Our ref: DOC21/1004177-7

Your ref: MP 10_0137 MOD14

**Mod to Huntlee PA (MP 10_0137 MOD 14) - Large Lot Changes (Cessnock & Singleton LGAs)
– Response to Submissions (Additional Information)**

BCD has reviewed the correspondence from Urban Ethos titled '*Response to request for additional information No. 4 – MOD 14 to MP_10_0137 Huntlee New Town, Branxton*' (dated 9 November 2021), including relevant appendices, annexures and attachments in relation to impacts on biodiversity and flooding.

Figure 3 Required APZ for the large lot site

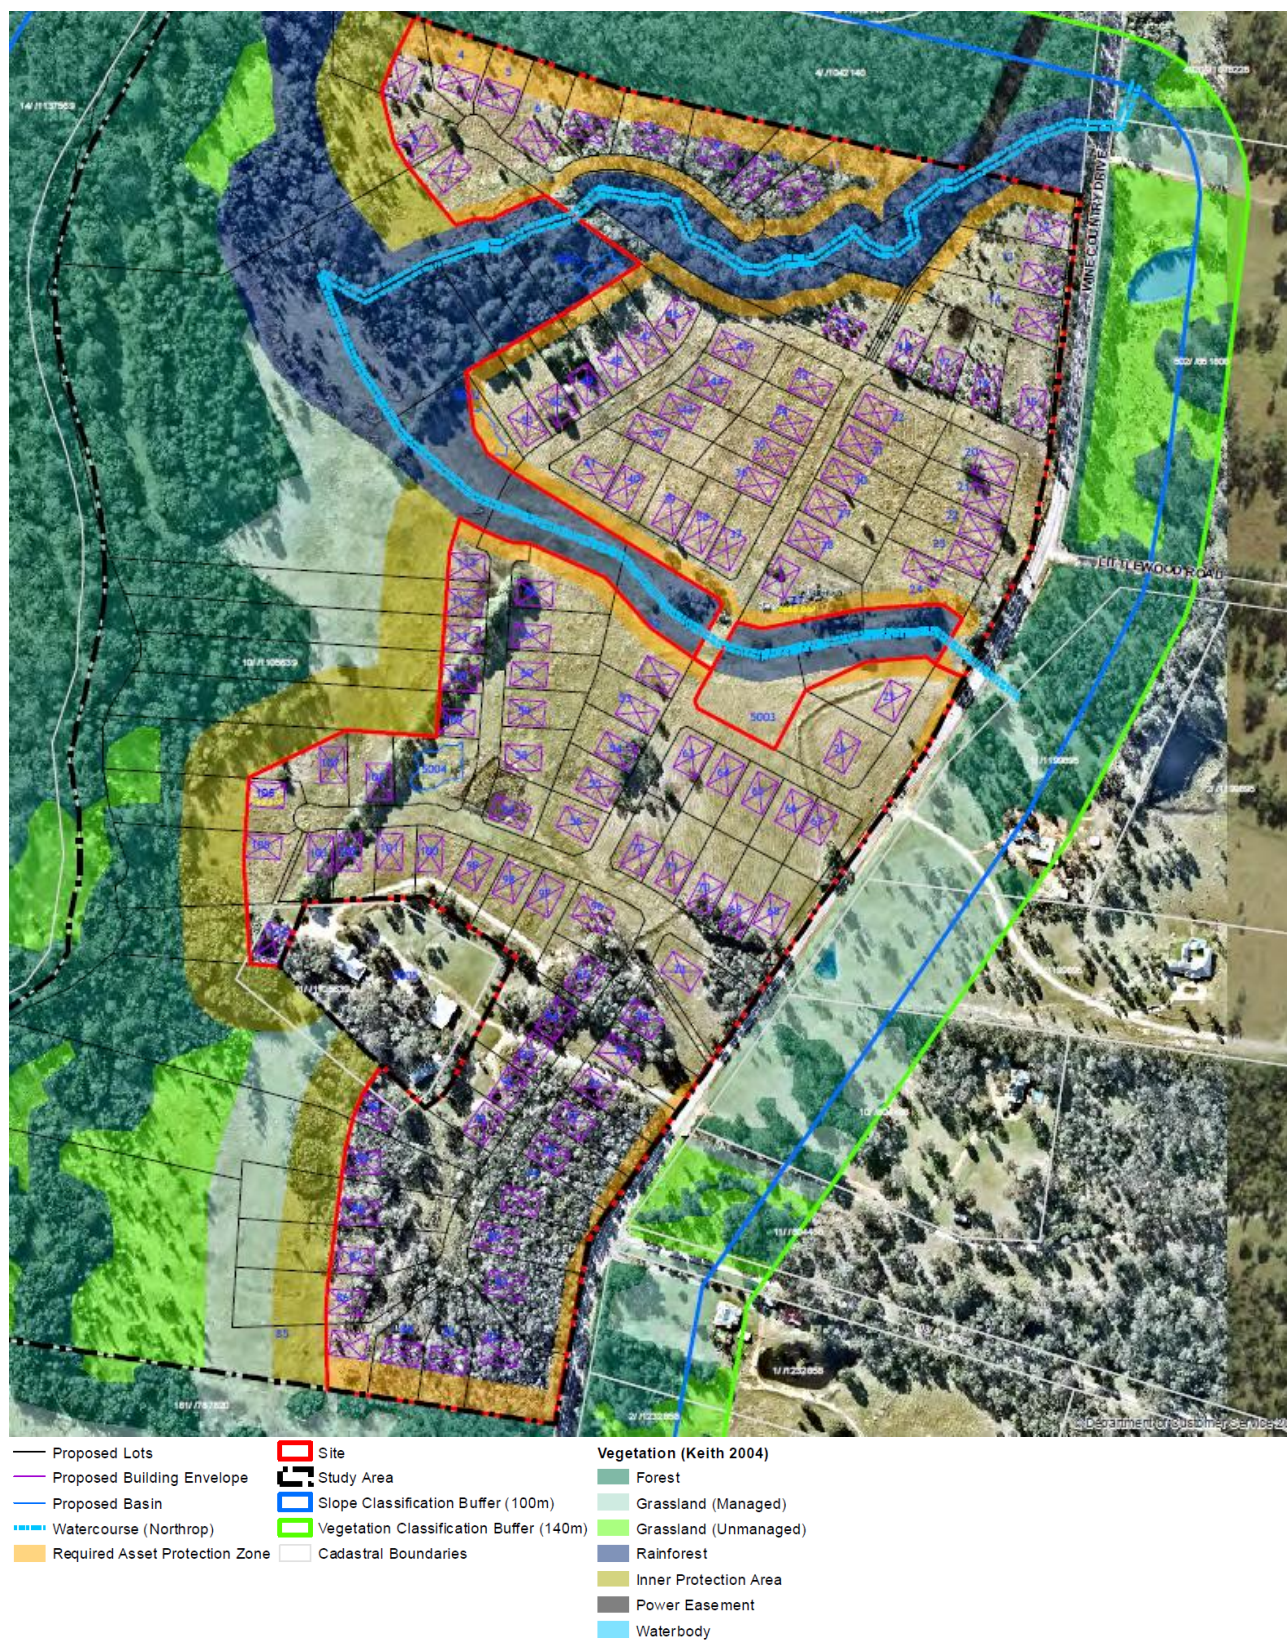
BCD notes that there appears to be a bushfire Asset Protection Zone (APZ) incursion into these buffer lands, as shown in the 'Figure' on page two of the MJD Environmental letter (dated 29 October). BCD would like the figure to be updated and the proponent made aware that such incursions are not permitted under the current Huntlee approval conditions. Additionally, the mechanisms to ensure the in-perpetuity protection of this habitat must be demonstrated.

BCD recommends that approval conditions C9(c) and C10 are retained and clearly explained to the proponent, to prevent any adverse incursions.

DRAWING NO: 20406-01-14
 PROJECT NO: 20406
 DATE: 17/06/2020
 SCALE: 1:3000
 SHEET NO: 1 OF 1

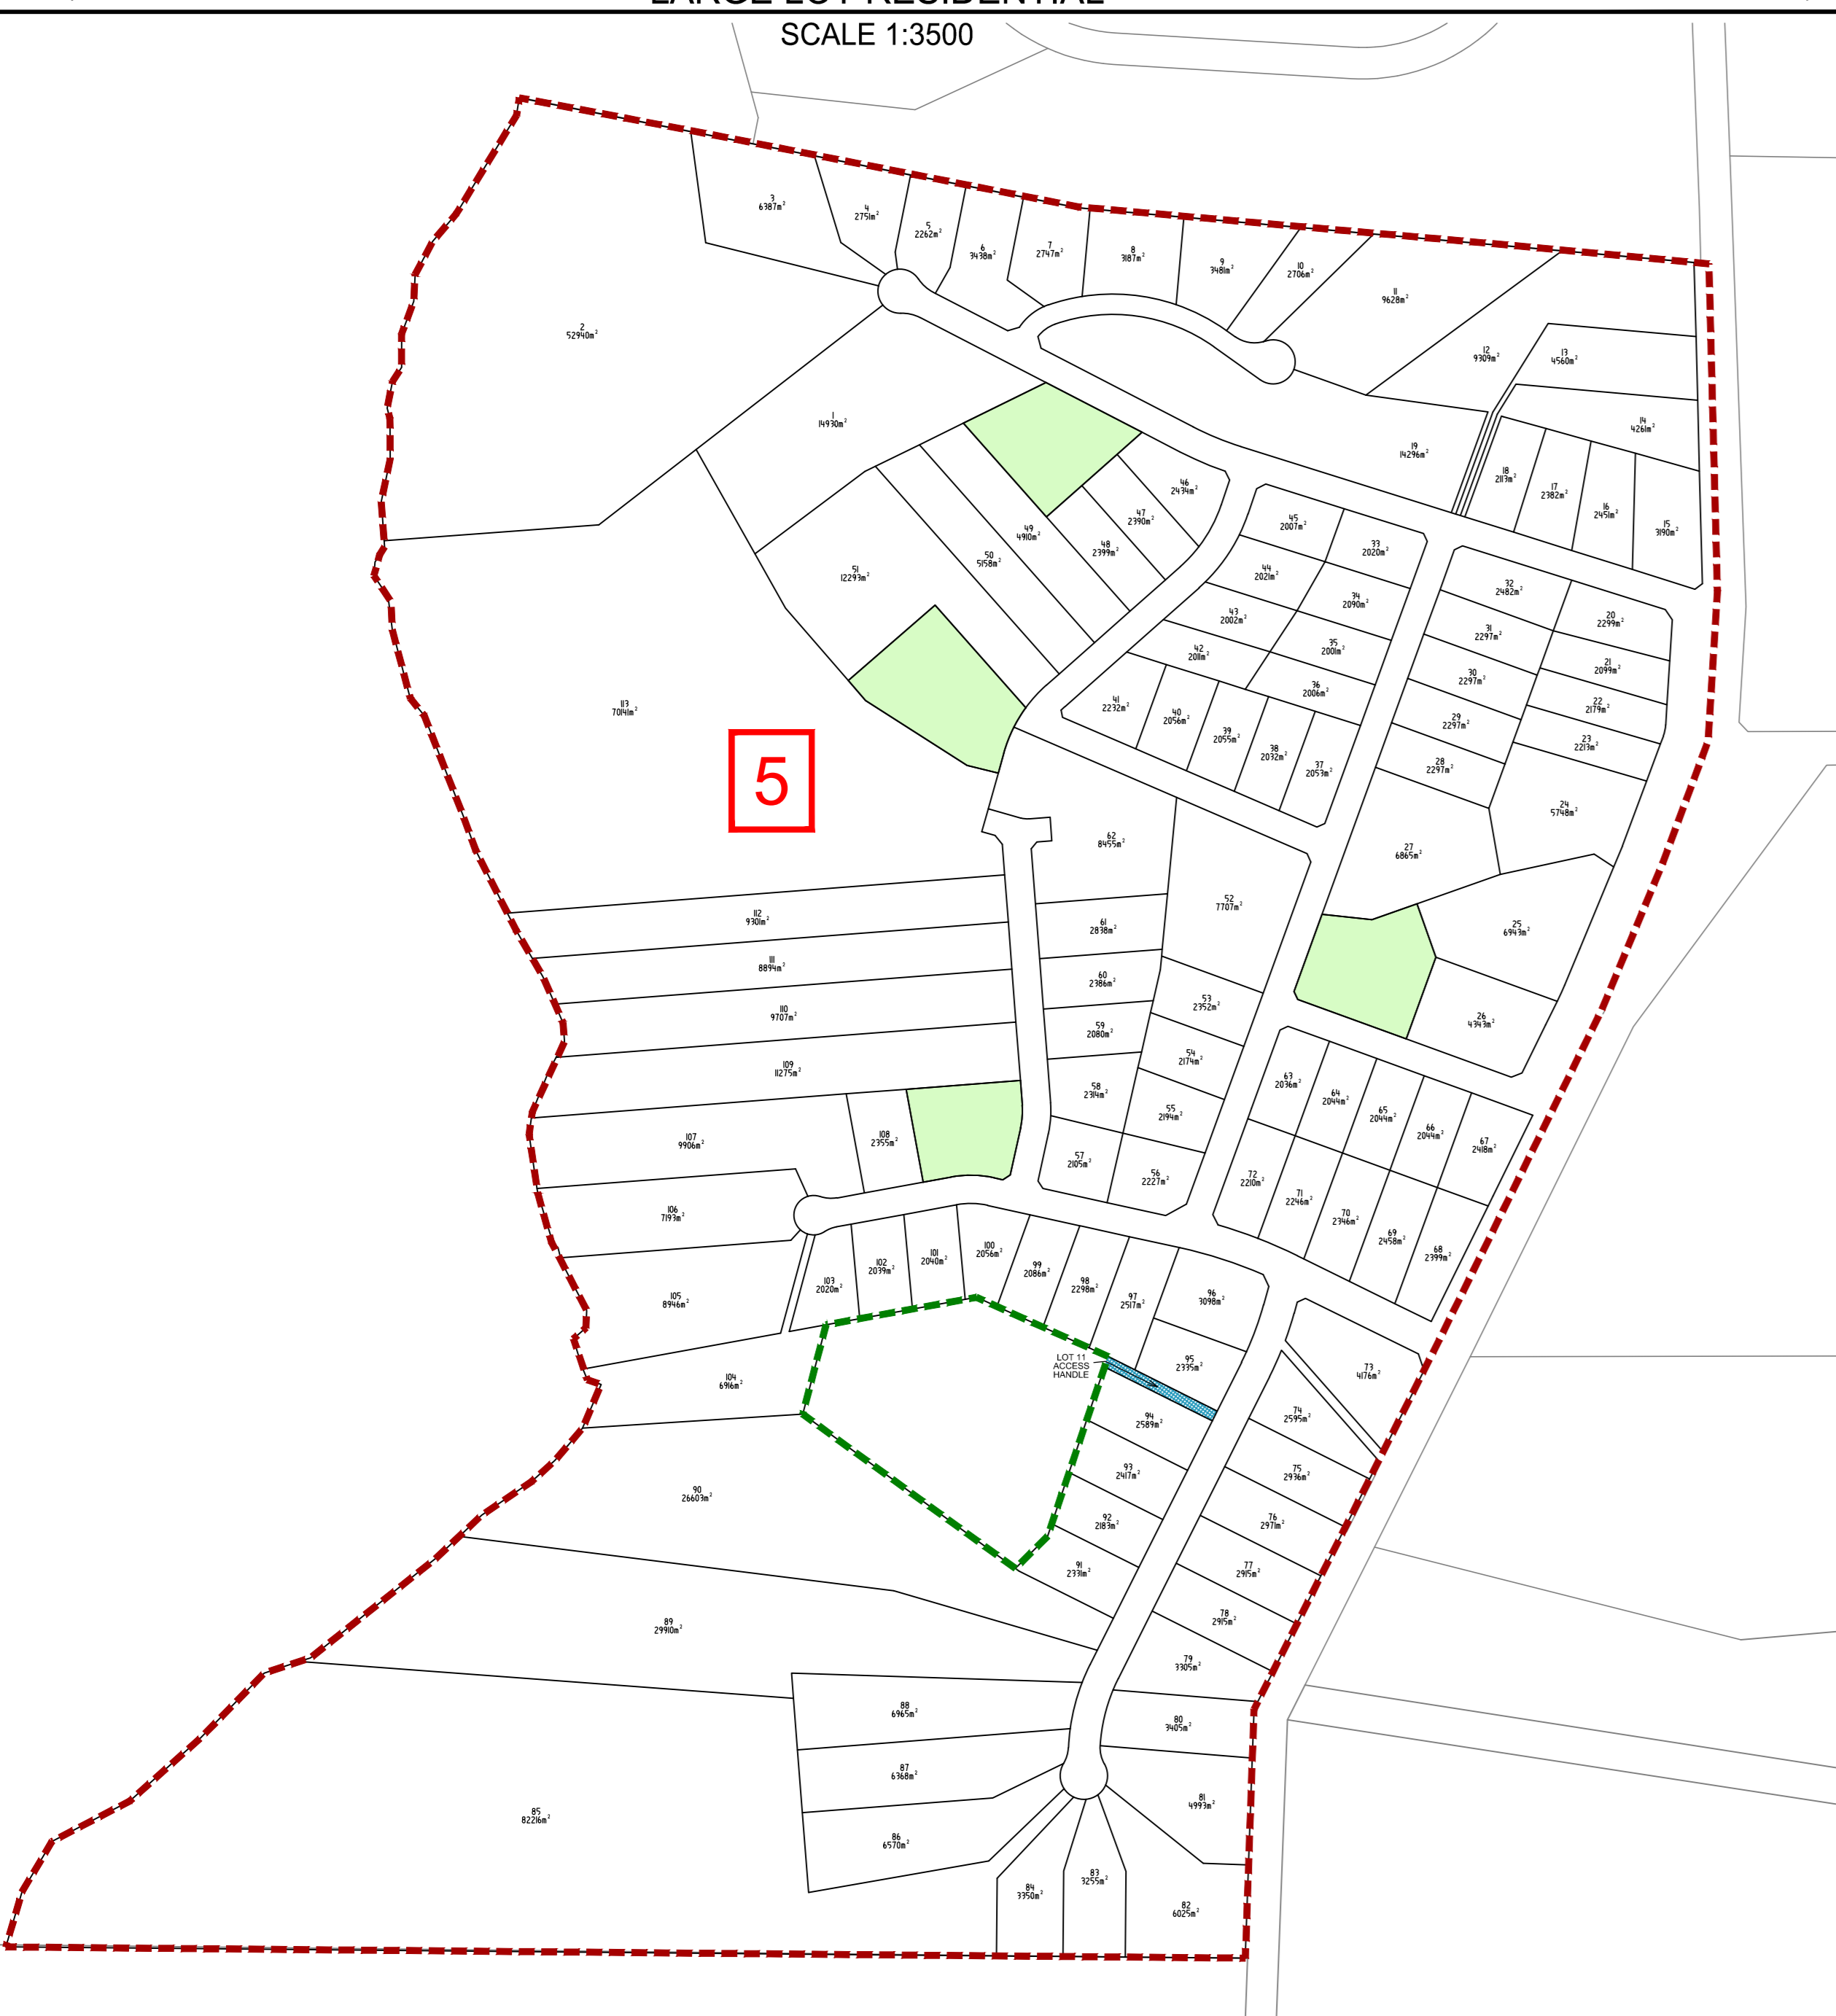
The approved lot layout for the Huntlee Subdivision contains three distinct riparian zones and local flooding is generally confined to these areas. MOD 14 proposes to remove these riparian zones, which cover 15.03 ha of public space and return them to private ownership. No consideration has been given to requirements for landholders to maintain these areas so that that flood behaviour is not affected. The response to submissions has indicated that the flood model has been revised to include a higher hydraulic roughness value for the riparian areas however the request for landscaping plans and maintenance details has not been addressed.

Riparian areas provide essential functions for flood and stormwater management for the Huntlee Subdivision and the proponent should demonstrate how these functions will be maintained if riparian areas are transferred from public to private ownership. Inspection and protection of EEC will be difficult when entry to private property for monitoring purposes is required. Private fencing may also make access and surveillance difficult. The proponent has not justified inclusion of protected riparian zones as part of the lot layout.

Northrop PMF Flood Depth and Extent

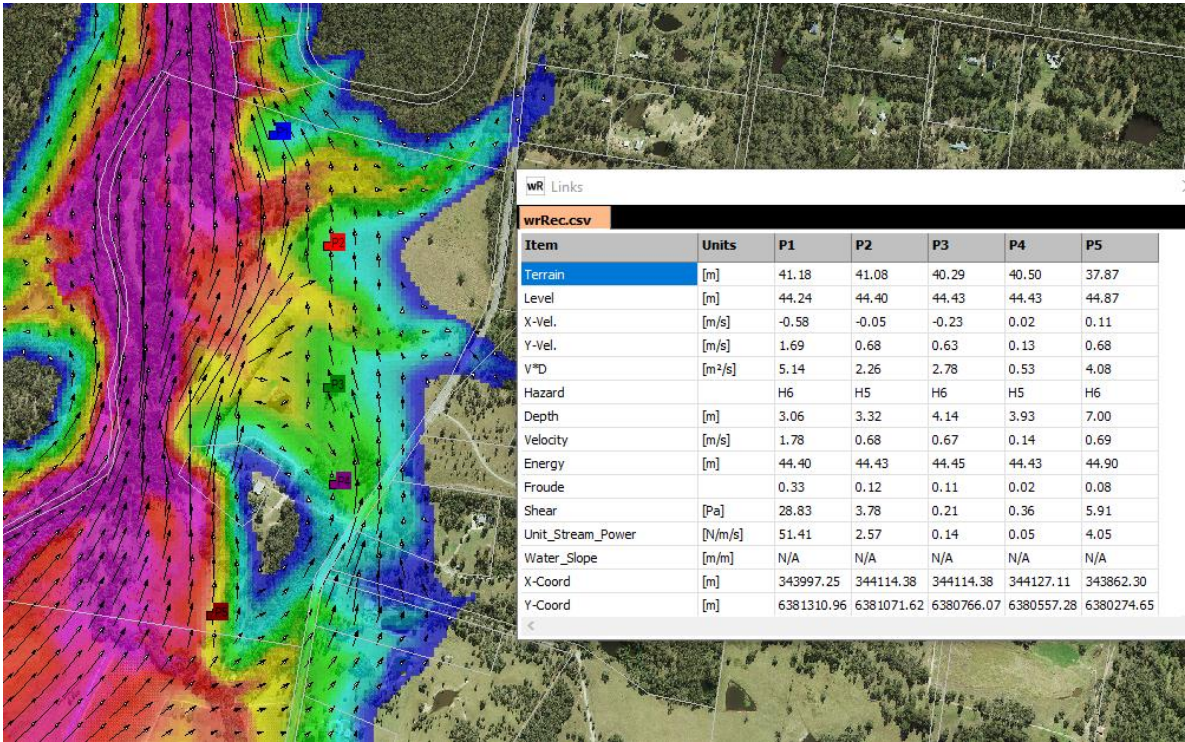
The MOD 14 flood assessment maps the 1% annual recurrence interval (ARI) and probable maximum flood (PMF) extents for local flooding. Flood mapping has now been provided by Northrop which shows the extent of flooding on the site which occurs in a PMF event from Black Creek Figure D5(A). For flood planning purposes the worst case of the local and regional flooding maps. The PMF map shows a significant portion of the site covered by in excess of 7m of flood water with most of the site subject to in excess of 3m of flood water. The associated flood hazard is H5 and H6 for most of the site. H5 hazard is considered unsafe for vehicles and people. All buildings are vulnerable to structural damage. Some less robust building types vulnerable to failure. H6 hazard is unsafe for vehicles and people. All building types are considered vulnerable to failure.

Full evacuation and extensive damage to private property would occur during a PMF flood. Evacuation of many of the planned residential sites would also be required for more frequent events such as the 200-year and 500-year flood events where flood depths of 1.5m to 3.8m were predicted in the earlier Worley Parsons Study. The 200 and 500 year ARI floods are often used by Councils as a proxy to predict likely flood risk under 2050 and 2100 flood scenarios. Floods in this locality during 2015 were estimated to be rarer than 1 in 200yrs resulting in the loss of a dwelling in Greta.

Prior to approval of the subdivision the proponent should prepare a floodplain risk management plan in consultation with Cessnock City Council and the Department to show how flood warning and emergency evacuation will be achieved for floods in excess of the 1% annual exceedance probability (AEP) event. The ethos urban report claims that flood risk is reduced because the total number of lots has been reduced from 123 to 105 in this locality. This does not change the substantial risk to life which remains in this area once it is used for residential purposes without any consideration of evacuation routes. Any costs associated with the provision of infrastructure required to protect life in this area should be borne by the developer and not be conferred to Council. The Department of Planning must satisfy itself that allowing this land to be developed for residential development purposes does not pose an unacceptable risk to life or property.
